Our ref: CN01

Date: 8<sup>th</sup> April 2025

**Thirdi**

**Re. Crows Nest OSD – Site B – Landscape Response to Wind Analysis – Re. Comment 7 and 9**

Project Crows Nest OSD - Site B	Issuer 	Sheet title CARPARK LEVEL 07
Client Third.i	Project number 121809	Size check 25mm
Checked Approved Checker Approver	Sheet size A1	Scale 1 : 100
	Sheet number DA-2217	Revision C

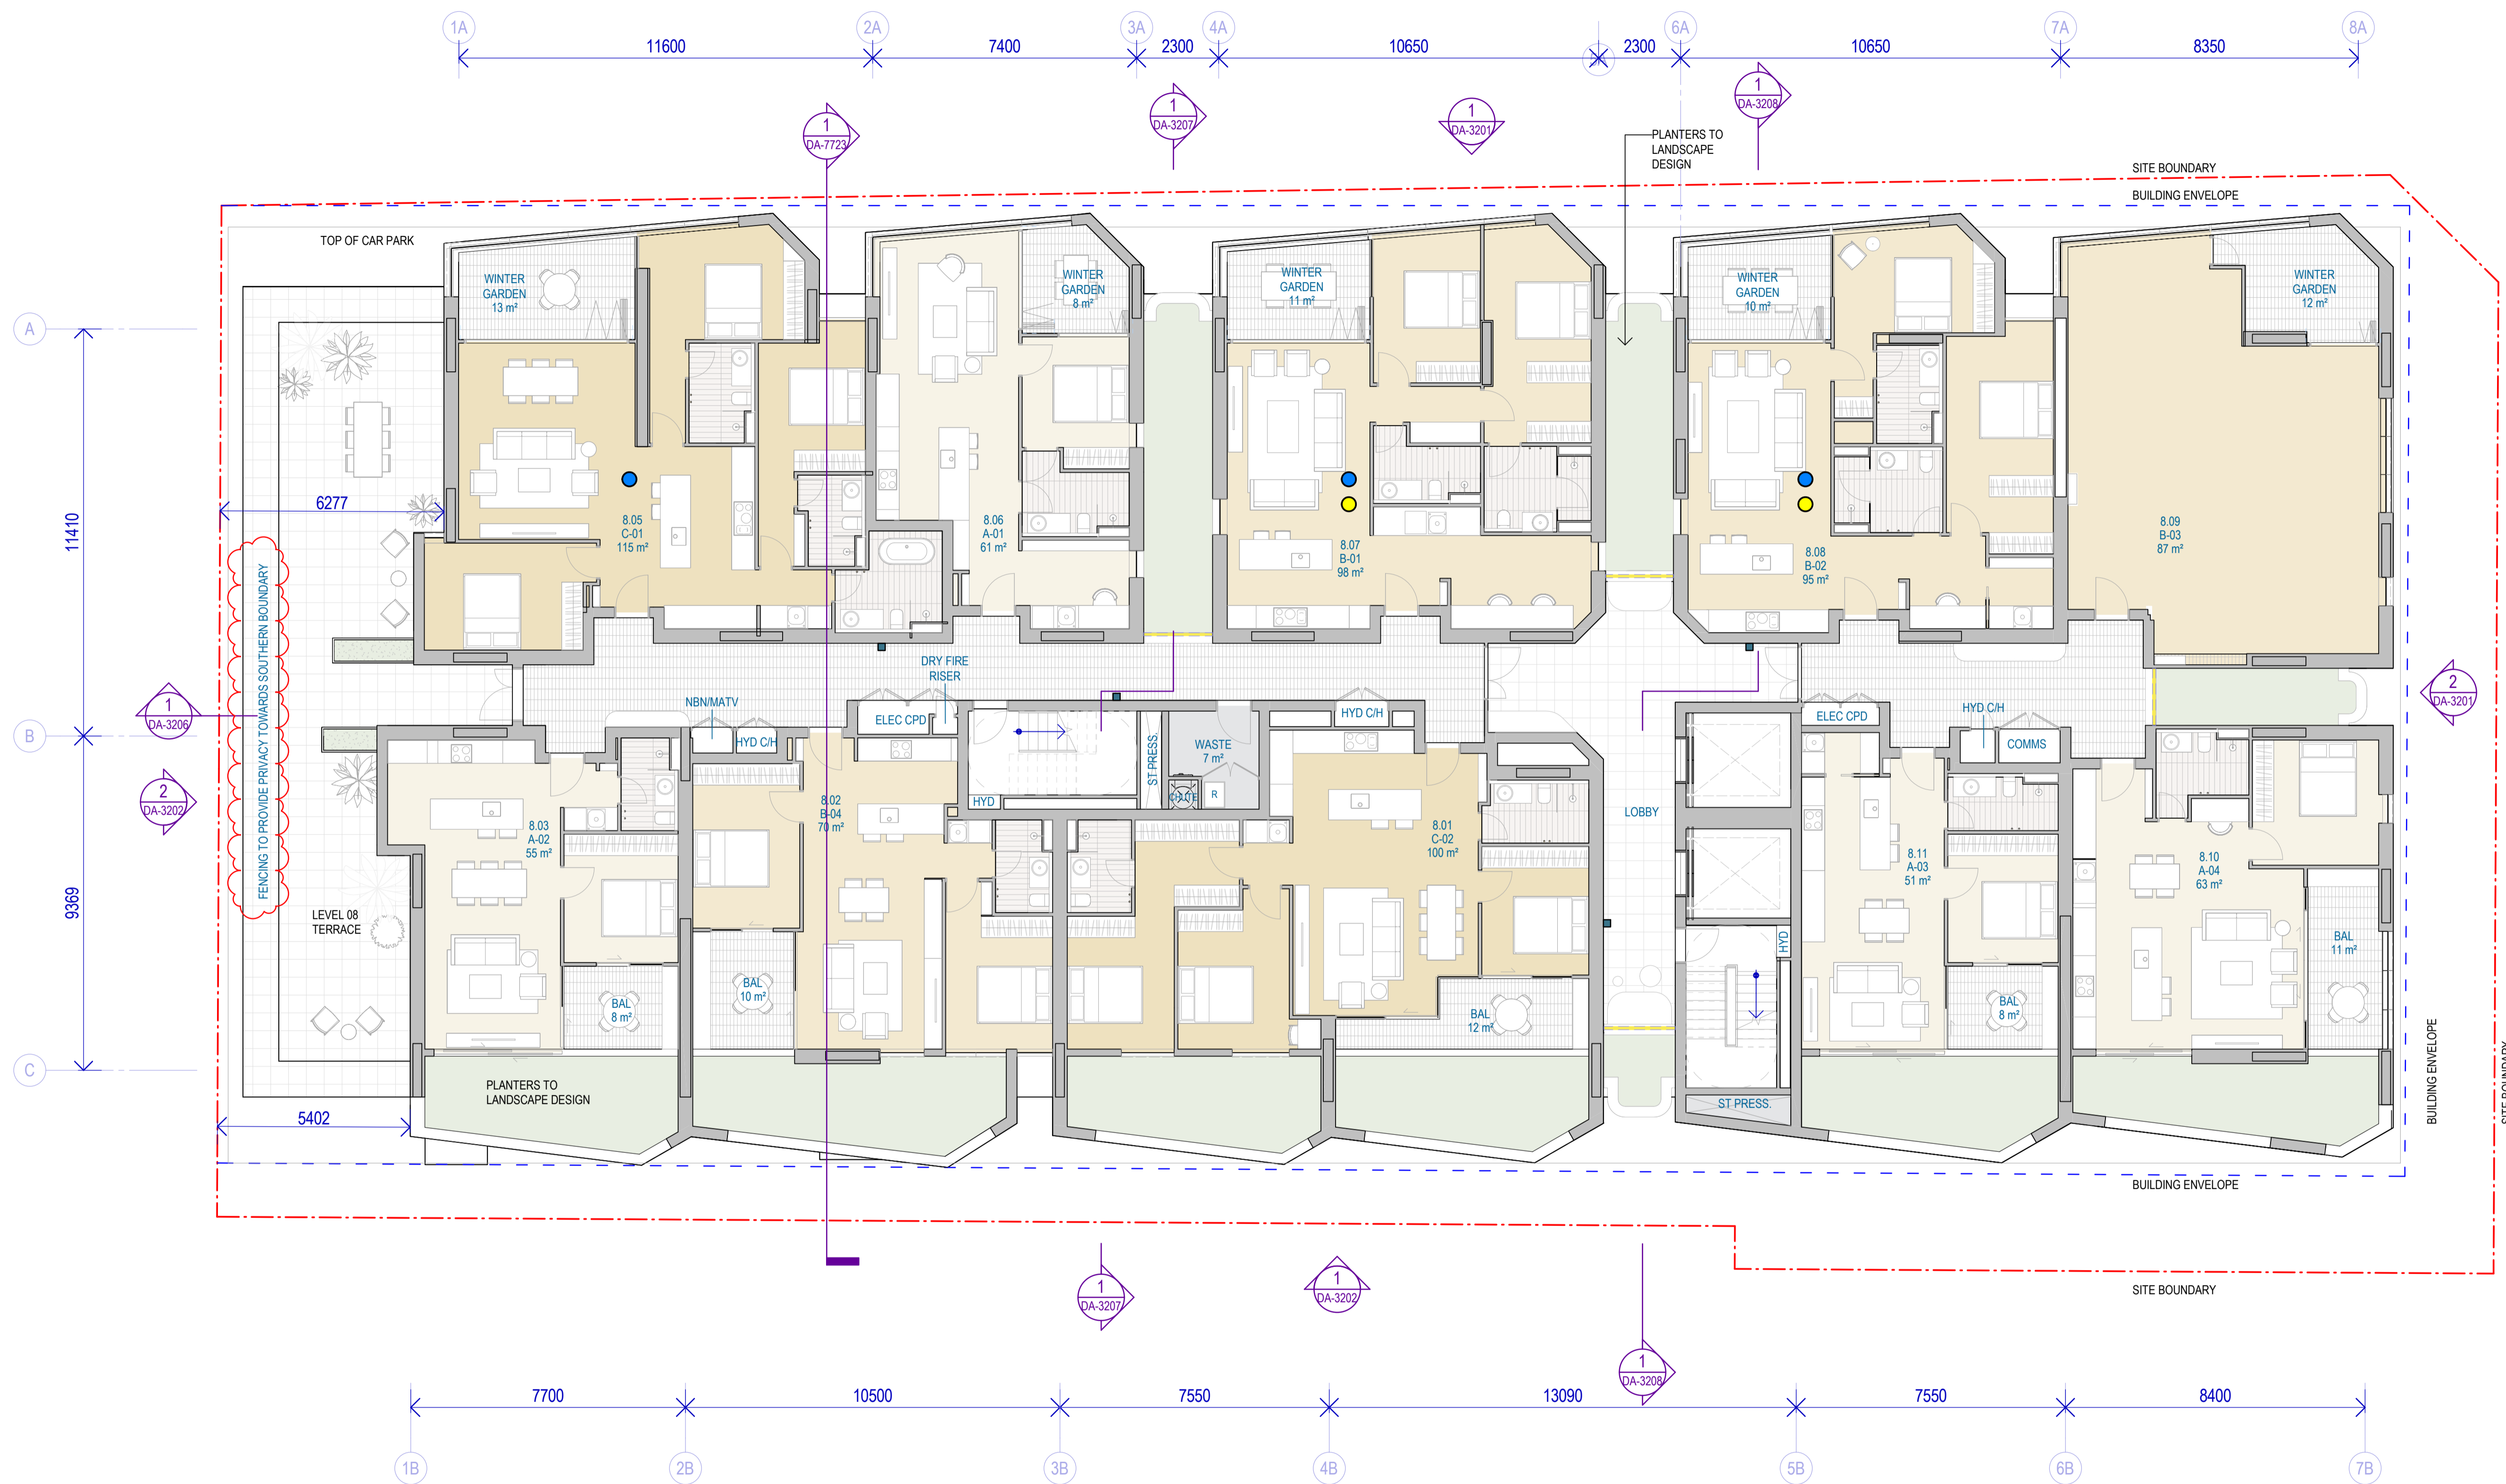
**9. Demonstrate that the proposed landscape design for the level 7 communal terrace will provide a green buffer and privacy for adjacent apartments. Consider extending planting towards the eastern side of the terrace and including continuous planters to enable a green edge, aligning with what is shown on the 3d visualisations.**

Our design for the level 7 terrace is based on providing a functional, multipurpose space for predominantly residents on that level. The design consists of trees and shrubs in large pots which will provide localised shade and to a degree, wind protection. The design focusses on flexibility, with the option to move some of the planters to address the specific needs of residents. Views outwards from the terrace are paramount and as such the design strategy maintained valuable view sheds from the plaza. Our team will review the design of the space and the number of planters at the next stage of the documentation, including an assessment of whether rectangular GRC planters containing small trees and shrubs should be added to address any concerns of the wind specialist. The response will also need to be co-ordinated with the structural engineers.
